Ardmore Park Quarry Modification 3 – EPA Comments

I refer to your email of 12 January 2018 in which you requested the NSW Environment Protection Authority's (EPA) comments on Multiquip Quarries Modification proposal for the Ardmore Park Quarry (the quarry) at Bungonia (Project Approval 07_0155).

EPA comments on Ardmore Park Quarry Modification 3 proposal

Figure 4 | Location of Sensitive Receivers

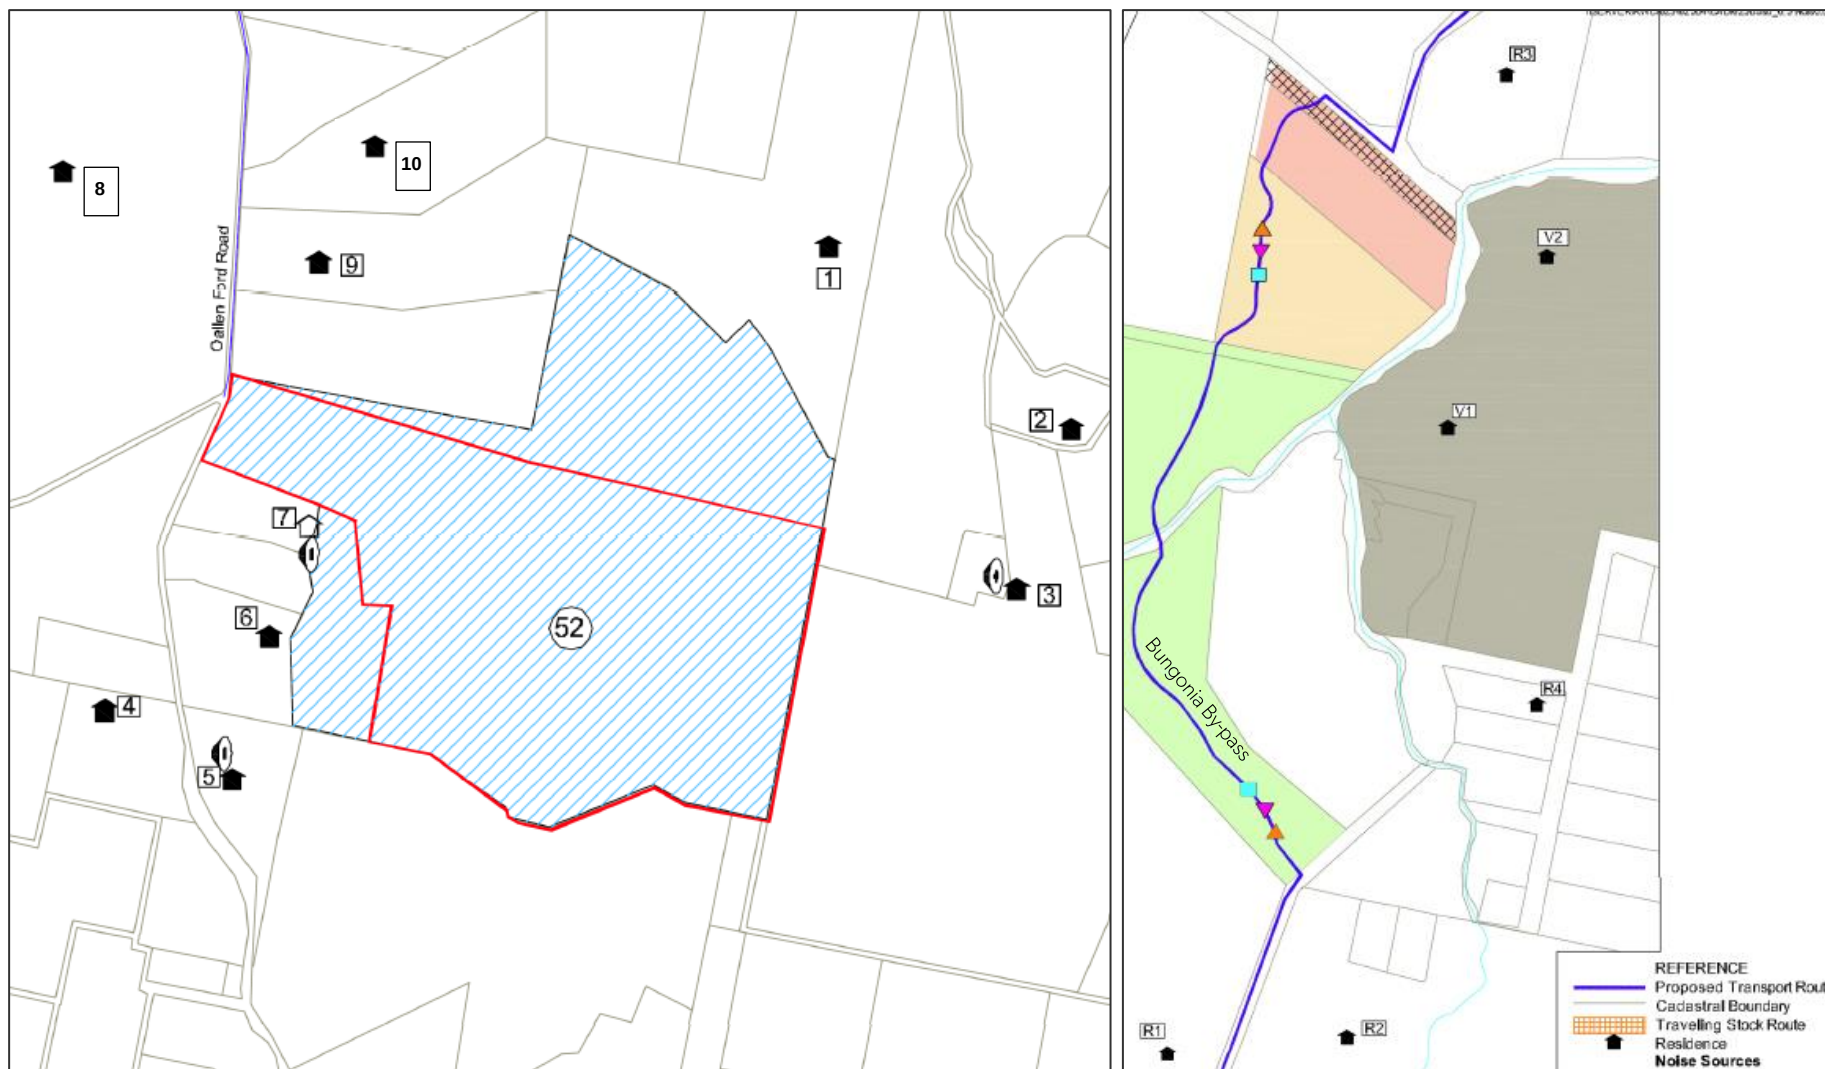
- **Recommendation: Update Table 3 in NIA with an accurate register of complaints reported to Multiquip and the EPA.**
3. Figure 3 Sensitive Receptor Locations in the NIA appears to indicate that Residence 6 is project related, however the NIA provides calculations for that Residence as if it were not project related. Table 1 of the AQIA indicates that Receptor R6 is a project owned residence.

- **Recommendation: Clarify which sensitive receptors are project related and which are not, as this has implications from a noise perspective in terms of agreed/acceptable impacts.**
